**PLANNING APPLICATION CONSULTATION RESPONSE**

<b>Application Number:</b>	3/2025/0363
<b>Proposal:</b>	Erection of 19 no affordable dwelling (100% affordable housing scheme) with associated car parking, landscaping and access from Pendle Street East, including demolition of existing domestic garages.
<b>Location:</b>	Land off Pendle Street East Sabden BB7 9EQ

**Objection 1 – Inadequate Surface Water Sustainable Drainage Strategy**

Lees Roxburgh Drg. Ref. 6757/01-03

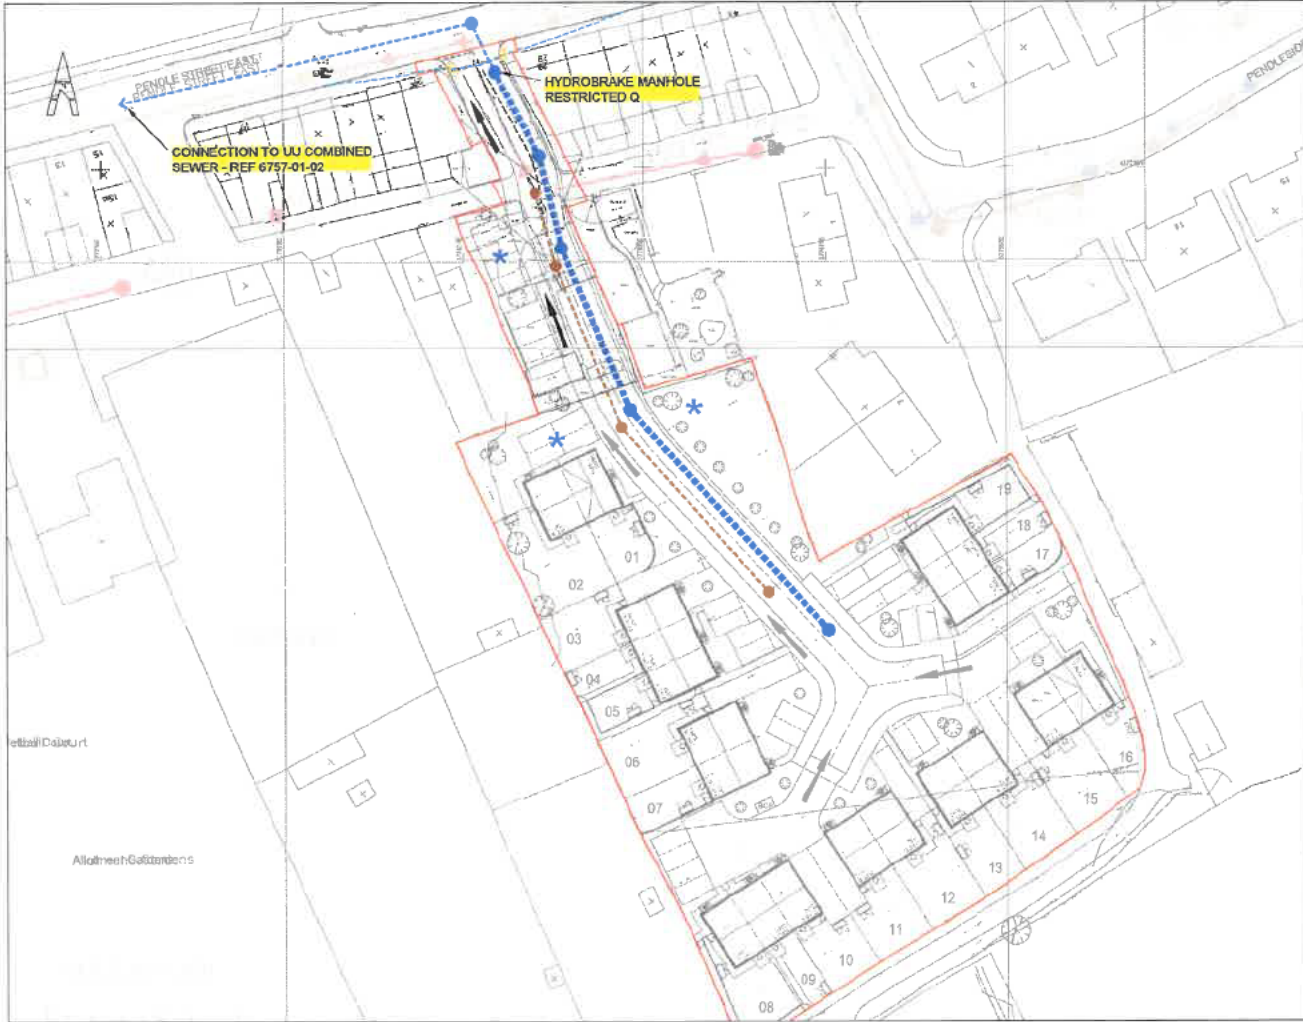
1. **Provide appropriate minimum operation standards for peak flow and volume control**, in line with the Defra Technical Standards for Sustainable Drainage Systems, therefore, is contrary to paragraph 182 of the National Planning Policy Framework.

The submitted surface water sustainable drainage strategy states that surface water from the site will be discharged at greenfield Qbar rates but fails to contain surface water volume flows within the parameters set out in Standard S6 of the Defra Technical Standards for Sustainable Drainage Systems as evidence has not been provided to demonstrate the how the greenfield Qbar rate for the site has been calculated. This is sufficient reason in itself for a refusal of planning permission.

- 3. Appropriately size the SuDS** and, therefore, does not provide appropriate proposed minimum operational standards, in line with Paragraph 182 of the National Planning Policy Framework. The submitted drainage strategy sizes the SuDS based only on the impermeable area of the site (approximately 0.303ha), excluding the remaining permeable areas of the site, but calculates the discharge rate based on the full site area of approximately 0.576ha.

The applicant must design their SuDS with an appropriate estimation of the area contributing to the drainage system, both permeable and impermeable, with evidence of this area provided through an appropriate contributing areas plan, or otherwise demonstrate how surface water runoff from non-drained areas will be managed without contributing to the drainage system and without increasing flood risk on or off-site.

The current failure to do so means the SuDS is likely undersized and, therefore, may contribute to increased flood risk on or off-site, contrary to the National Planning Policy Framework. This is a sufficient reason in itself for the refusal of planning permission.
